WEST SUSSEX COUNTY COUNCIL CONSULTATION

TO:	Arun District Council FAO: Katie Sharp
FROM:	WSCC - Highway Authority
DATE:	7th June 2022
LOCATION:	Central Wetland Area Hampton Park Toddington Lane Littlehampton BN17 7PL
SUBJECT:	LU/369/21/RES Approval of reserved matters following outline consent LU/47/11/ (amended under LU/182/15/PL) for the main on-site infrastructure at Hampton Park and encompasses: 1) the Central Wetland Area, 2) the main spine road and crossing structures & 3) the SUDs features. Revised plans received.
DATE OF SITE VISIT:	n/a
RECOMMENDATION:	More information required
S106 CONTRIBUTION TOTAL:	SEE LATEST VERSION OF S106 AGREEMENT

This is the fourth WSCC County Highways (CHA) response to the above planning application for approval of reserved matters following outline consent LU/47/11/ (amended under LU/182/15/PL) for the main on-site infrastructure at Hampton Park and encompasses: 1) the Central Wetland Area, 2) the main spine road and crossing structures & 3) the SUDs features.

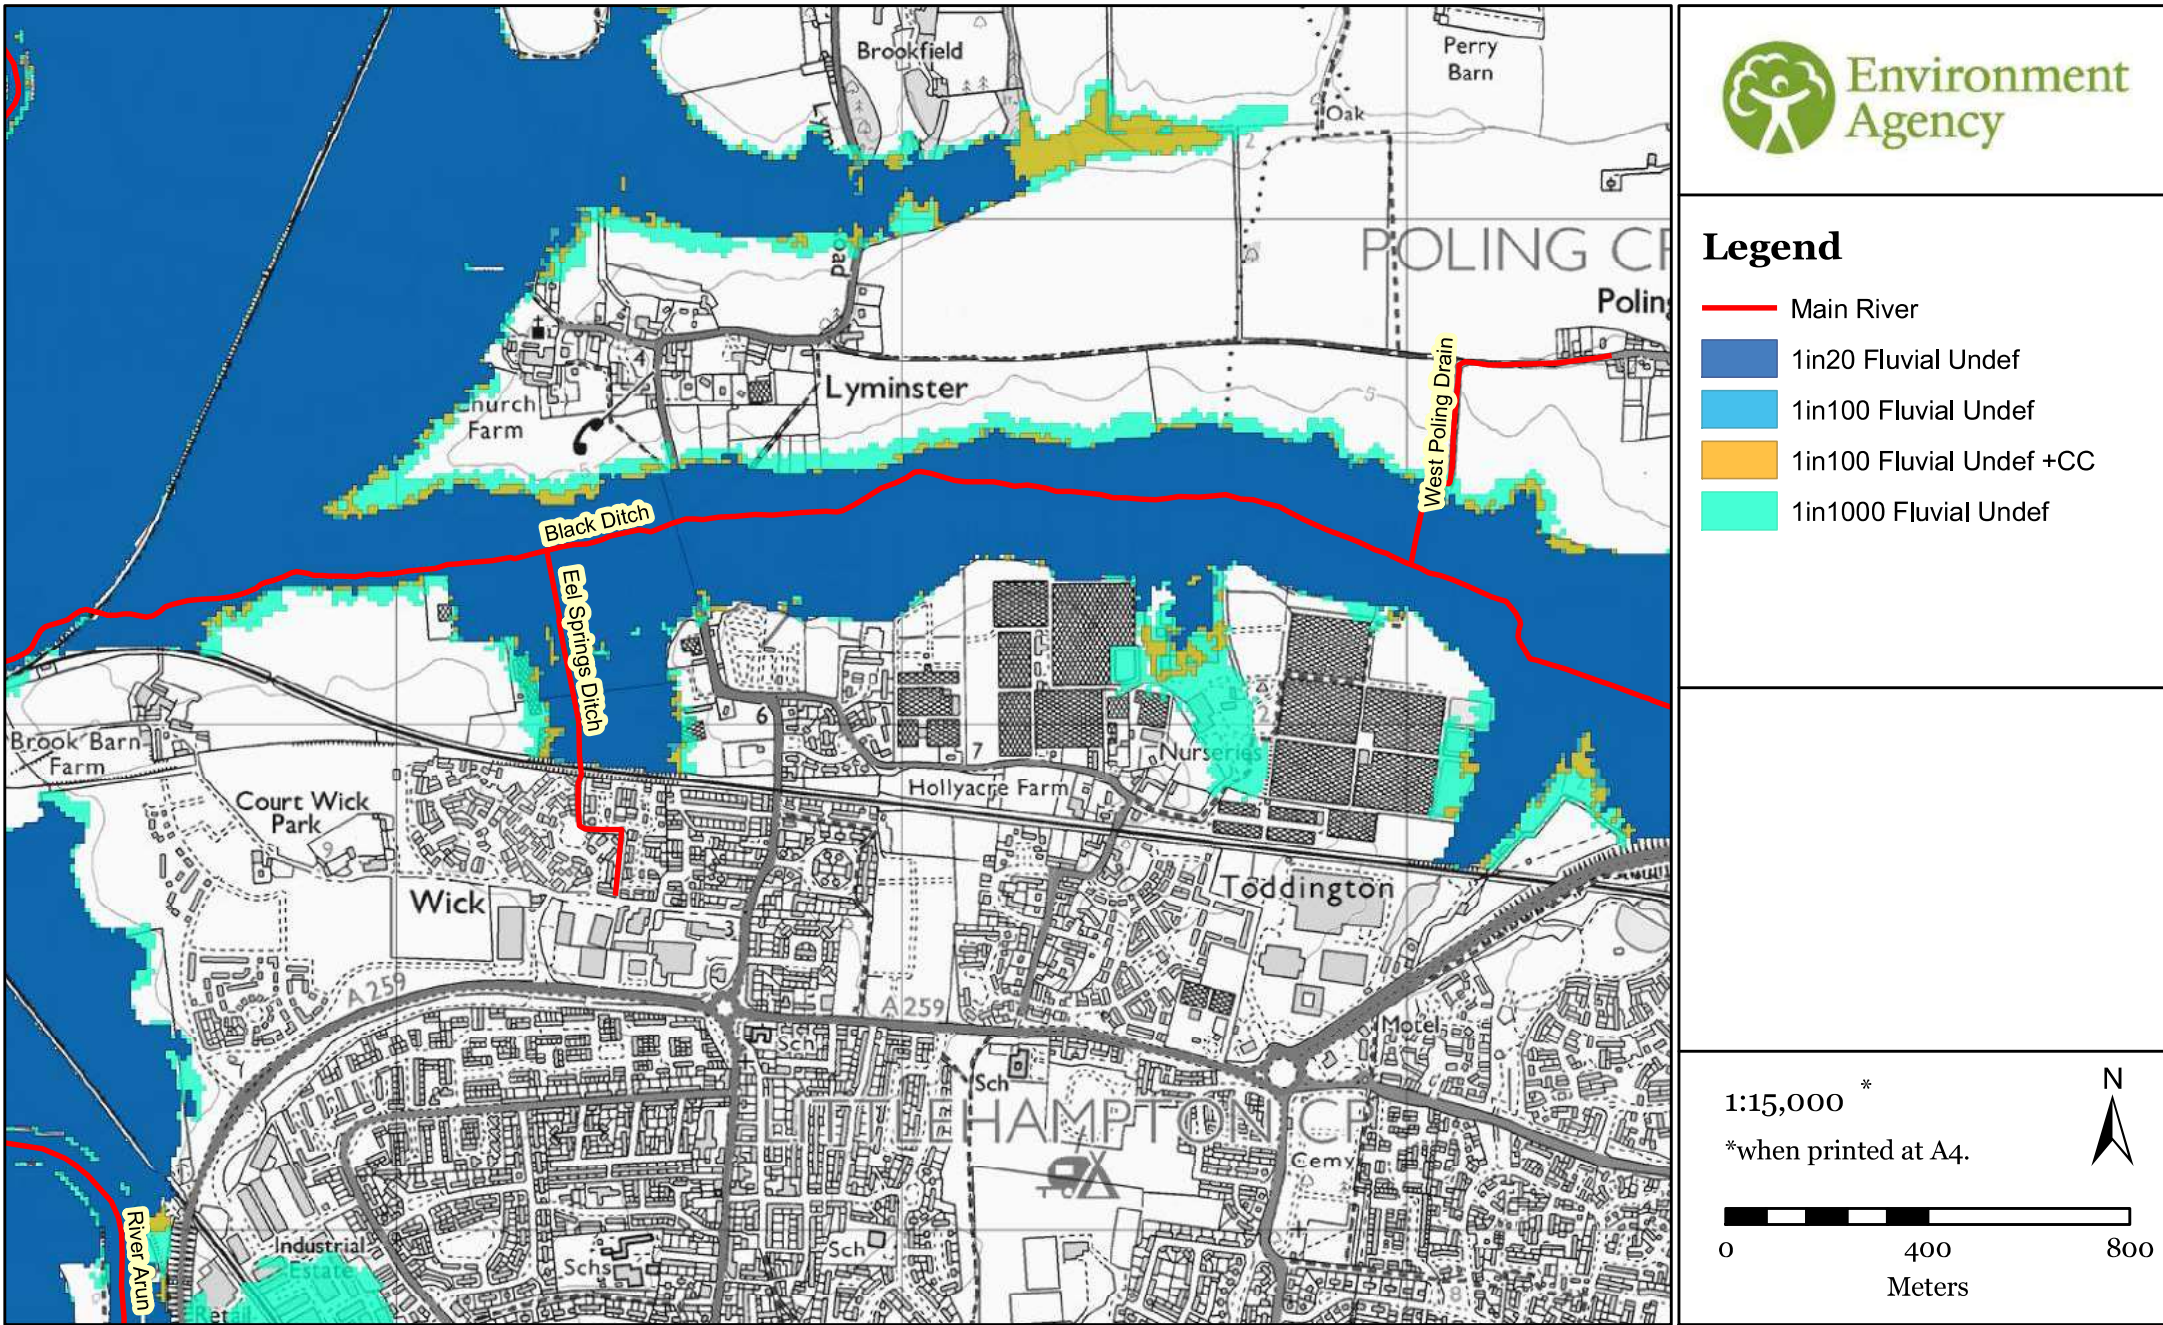
5. On the second set of 'drainage plans and appendices', on the first page it shows 3No. culverts all of which are 2m span but only 1.0m high. These are below the 1.2m minimum headroom defined in CD 529. Applicant to note that a headroom above the minimum is expected.

The applicant has noted the previous WSCC CHA comments about the minimum 1.2m headroom for culverts defined in CD 529. They have stated that the shared use paths and culverts in the wetland will not be offered for adoption. They also state that the footpath levels are such that the minimum headroom requirement cannot be achieved for the culverts. These are also less than 12m in length, and therefore the designer considers that the 1.2m minimum headroom should not be required for these structures. They reference Mayer Brown "Proposed Levels and Drainage" drawing ref. PHLITTLE-CWA.10/20. for more details.

structures accordingly. The design submission will need to provide a sound technical reasoning for any lower than desirable headroom proposed.
